**From:** Melissa Rassack  
**Sent:** Wednesday, 17 November 2021 10:52 AM  
**To:** William Hodgkinson; Rebecka Groth  
**Cc:** Jane Grose  
**Subject:** RE: Notice of Exhibition – Access Logistics Park (SSD-17647189)

- DCP – The Department is close to finalising the Mamre Road Precinct DCP. The SSDA should comply with the DCP once finalised.
- Setbacks – Setbacks should be consistent with the Mamre Road Precinct DCP and be measured from the new boundary (post road widening of Mamre Road).

LOT 2 - Site Plan / Ground Floor Plan / Fencing Plan

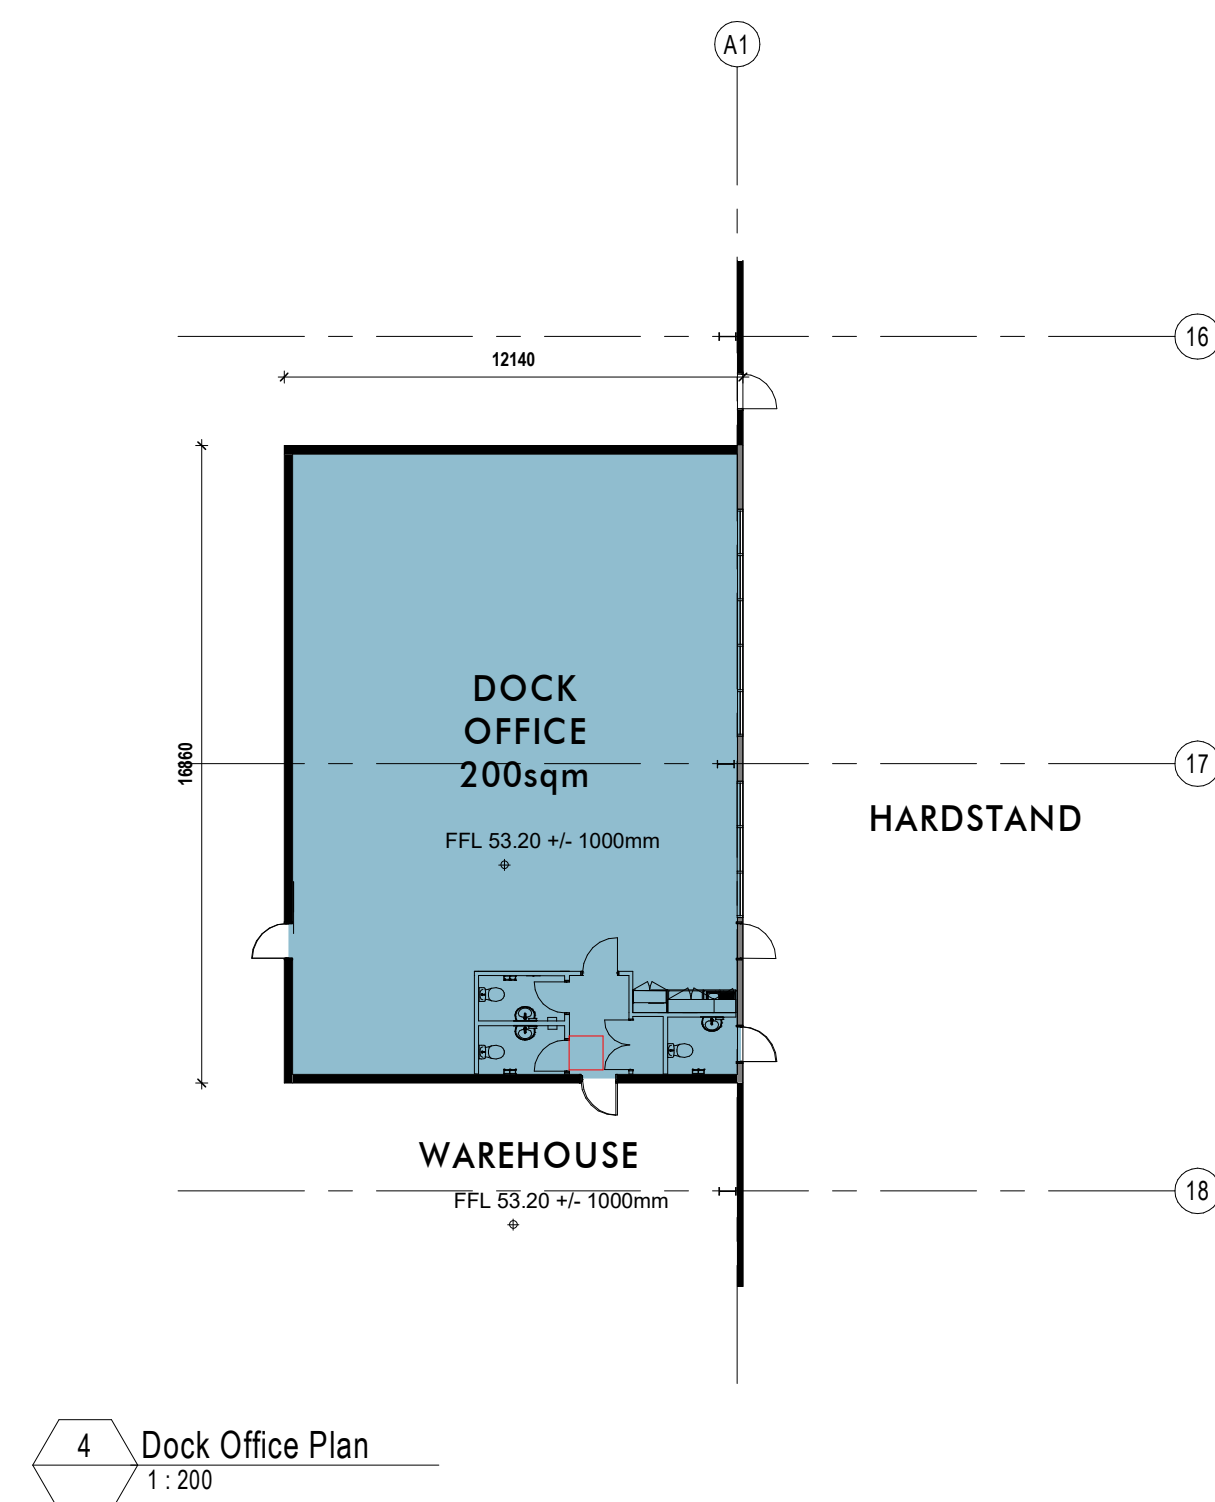
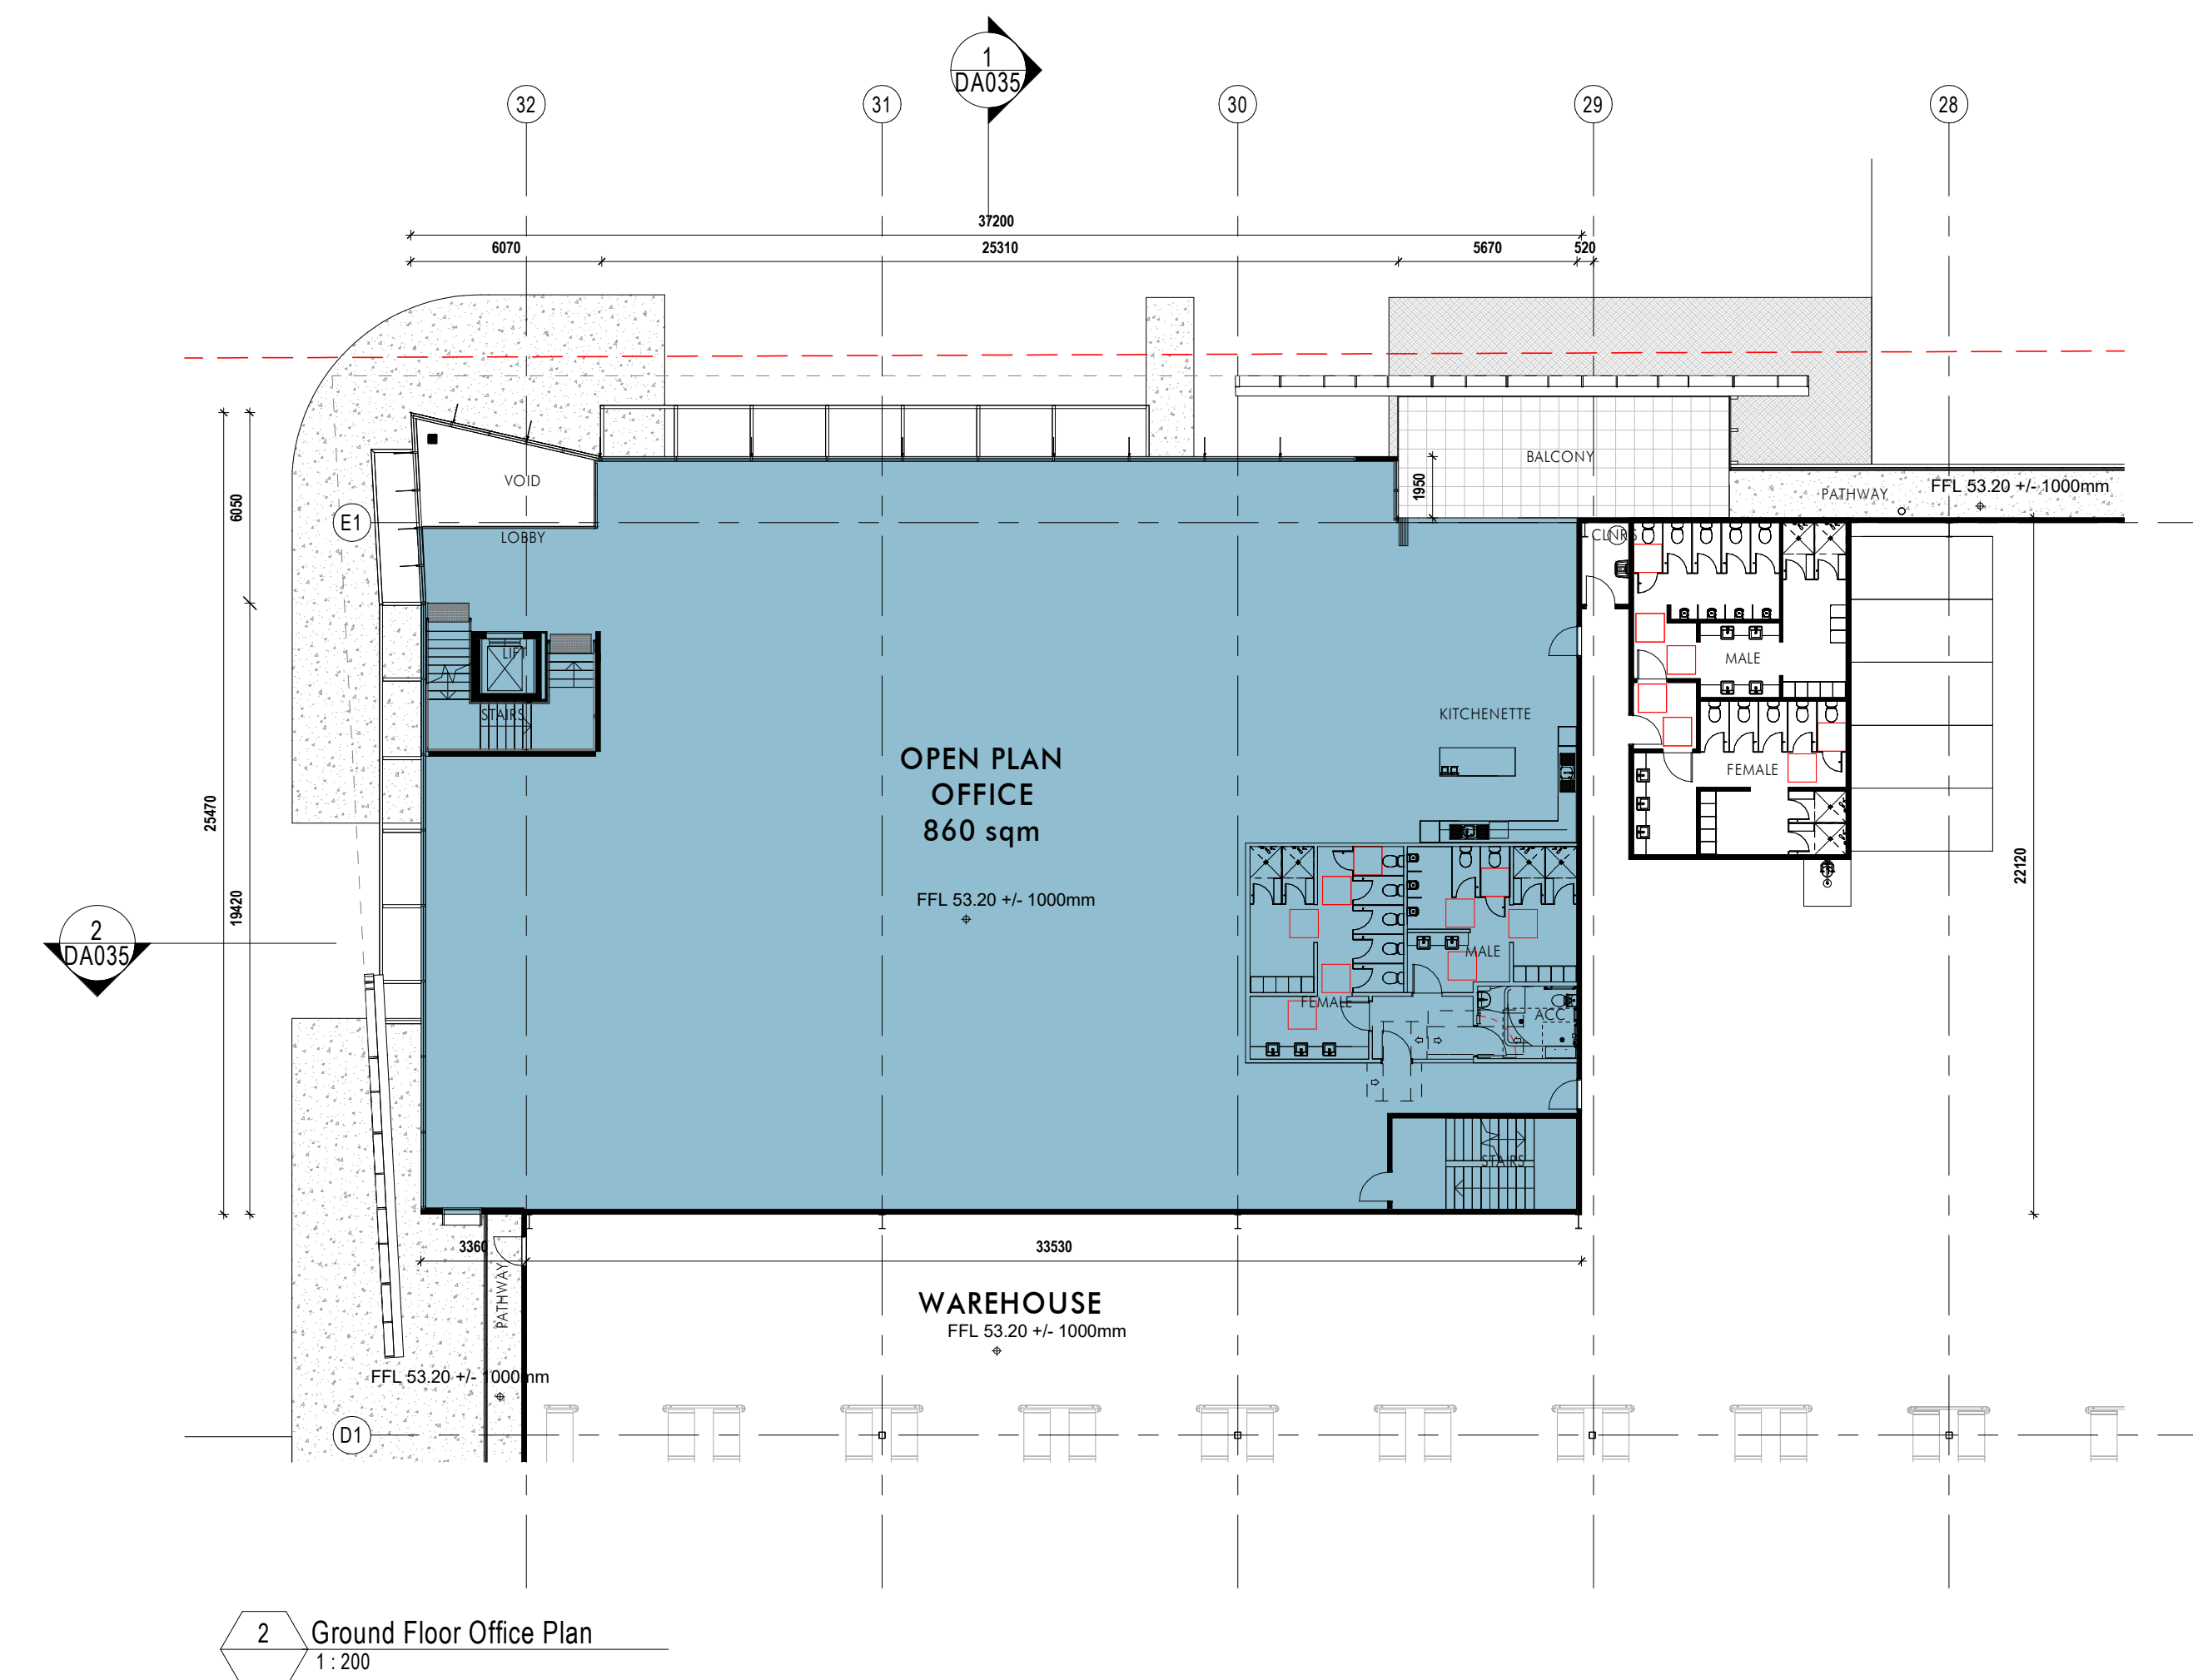
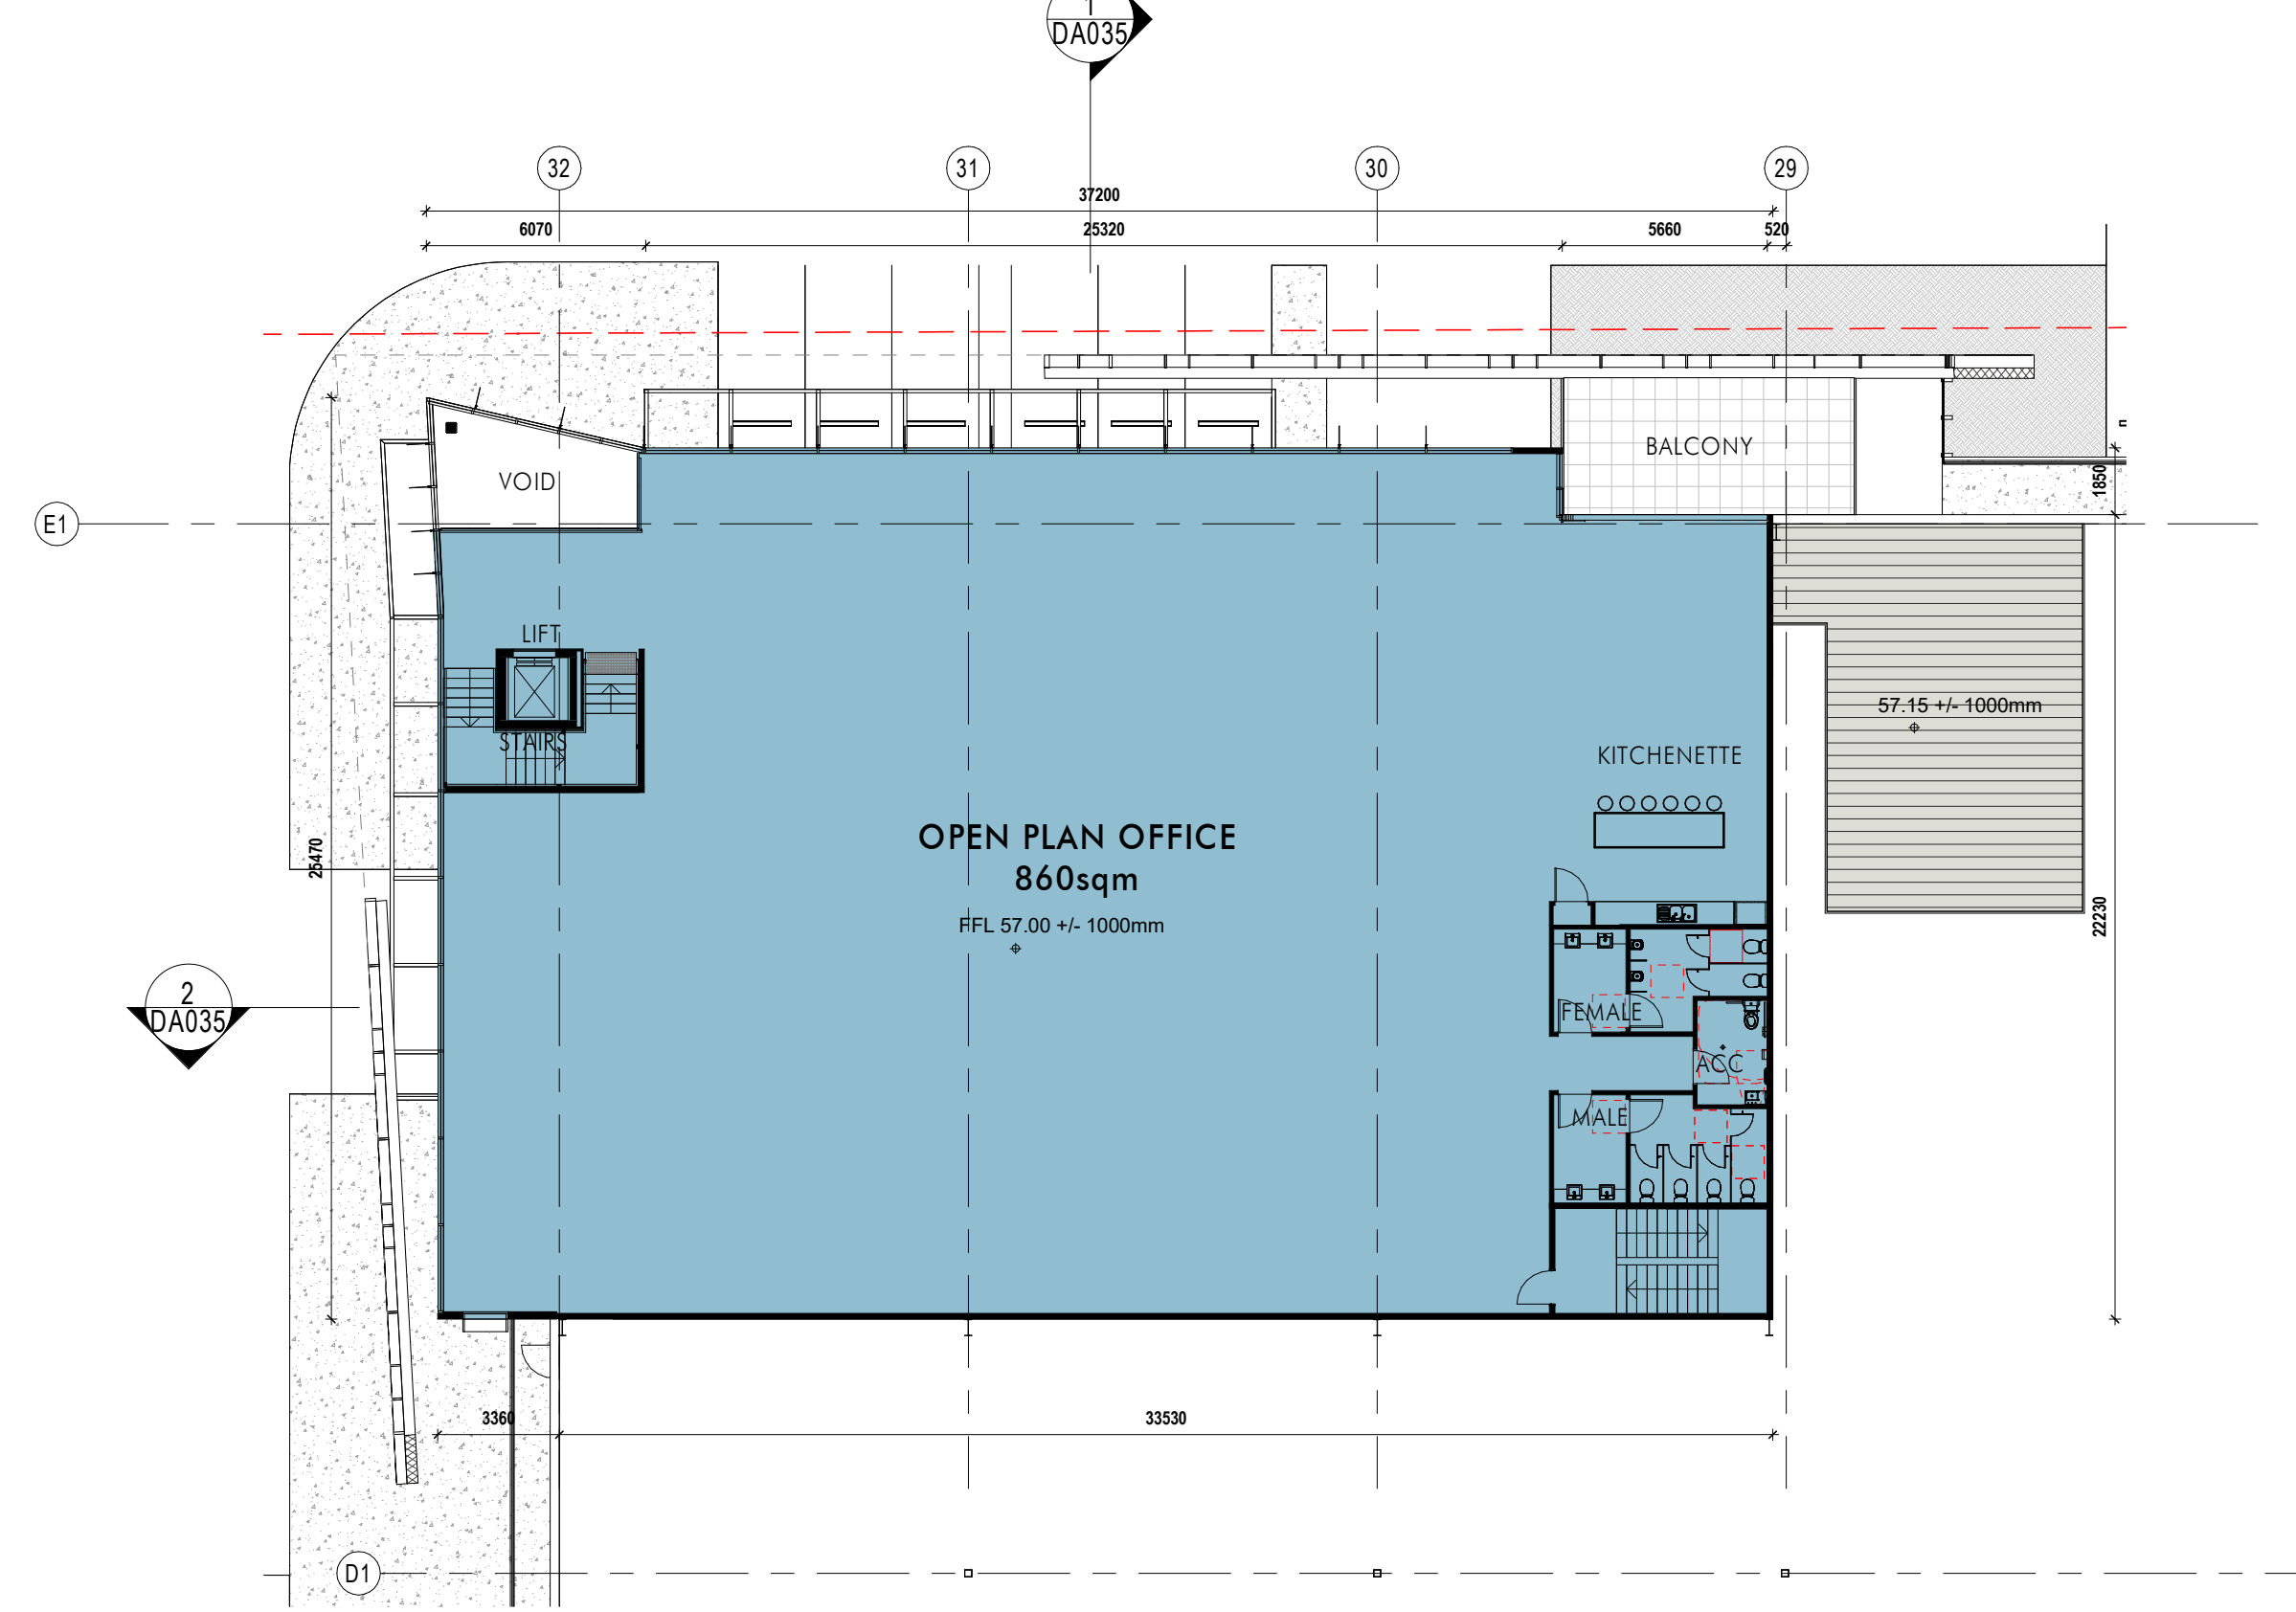
- Pervious surfaces – The submitted Landscape Design Report identifies that Lot 2 achieves a pervious area of 6.4% plus within parking areas. The development must demonstrate compliance with the minimum 15% per lot (excluding streets) pervious surface development control within the draft Mamre Road Precinct DCP.

- Tree Canopy – Confirmation of percentage of tree canopy is sought (excluding street trees). A target of minimum 10% tree canopy on development lot should be achieved.

- Earthworks – It must be ensured that earthworks must meet the requirements of cl. 33H and 33L of the WSEA SEPP, including the effect of the proposed development on the exiting and likely amenity of adjoining properties. Retaining walls adjoining the public domain greater than 2m should be stepped with suitable landscaping, with a maximum retaining wall height of 6m.
